Ribble Valley Borough Council
Council Offices, Church Walk
Clitheroe
BB7 2RA

Your ref: 3/2021/0205
Our ref: DC/21/961
Date: 20-APR-21

Location: Land at Neddy Lane Billington BB7 9LL

Proposal: Proposed erection of 36 residential dwellings, along with landscaping and associated site infrastructure

Drawing Title: **Detailed Site Layout**

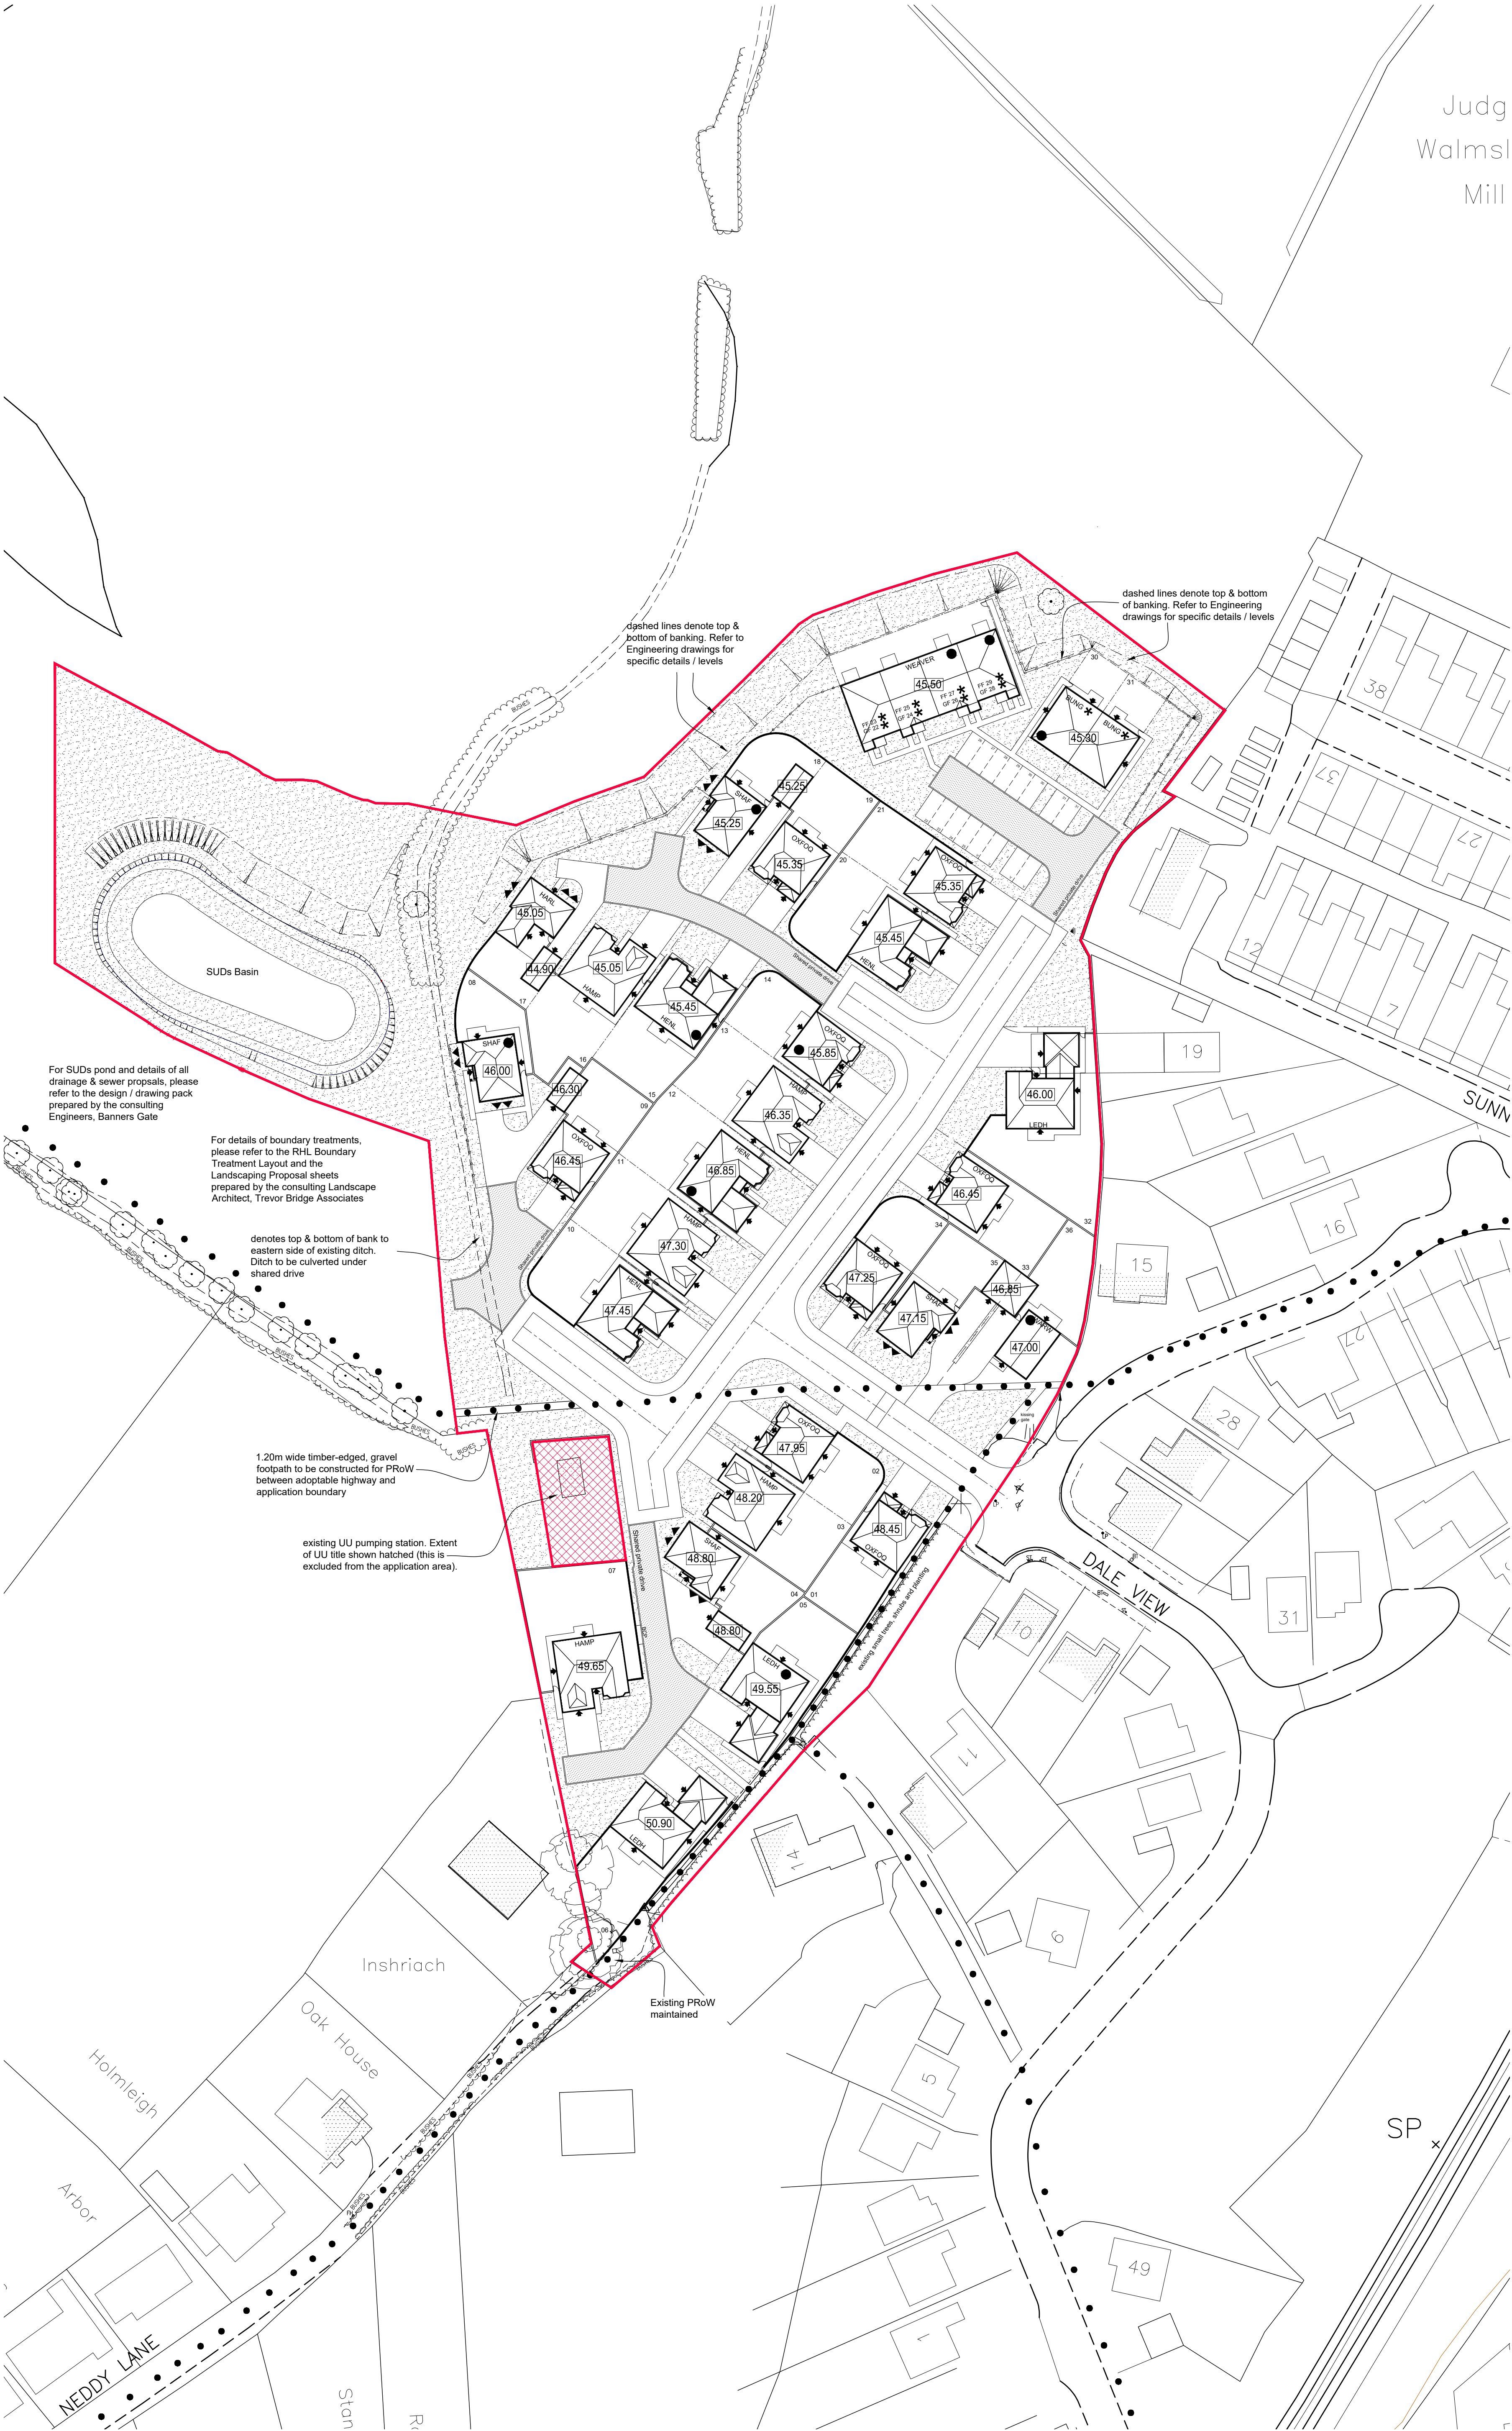
- United Utilities has reviewed the submitted documents and notes that the proposed layout plan includes land within our ownership, known as Billington Wastewater Pumping Station. In addition the applicant is advised that United Utilities has restrictive legal easements and a right of access that is used to access its wastewater pumping station. The applicant must ensure our 24 hour access to our asset within the site is maintained and available both during and post construction. The applicant seek must formalise an access for United Utilities to access our apparatus post completion. It is recommended that the approach to both our land ownership, access route and easements within the site should be clarified as soon as possible, to avoid any delays in delivery. The applicant should contact the Property Services team via PropertyGeneralEnquiries@uuplc.co.uk. More details can be found below within the '*United Utilities' Property, Assets and Infrastructure*' section below.

- We are aware of the applicants proposal to United Utilities to divert our sewer running through the site. It must be understood by the applicant and the LPA that the details of the diversion have not been agreed. We would strongly recommend the diversion route and estimate is agreed with United Utilities prior to determination, to avoid any complications should the application be approved. Again, more details can be found below within the '*United Utilities' Property, Assets and Infrastructure*' section below.

The applicant should be aware of the 15 metre offset from the existing pumping station as stated in the [Design and Construction Guidance](#). This is designed to minimise the impact of the existing asset on the proposed development. It is recommended that this is discussed further with Developer Engineer, **Robert Brenton**, by email at wastewaterdeveloperservices@uuplc.co.uk

It is the applicants' responsibility to identify the exact location of United Utilities infrastructure and the necessary diversion details must be agreed as it likely we will not allow building over of the asset and would need to be afforded suitable access for maintenance and repair.
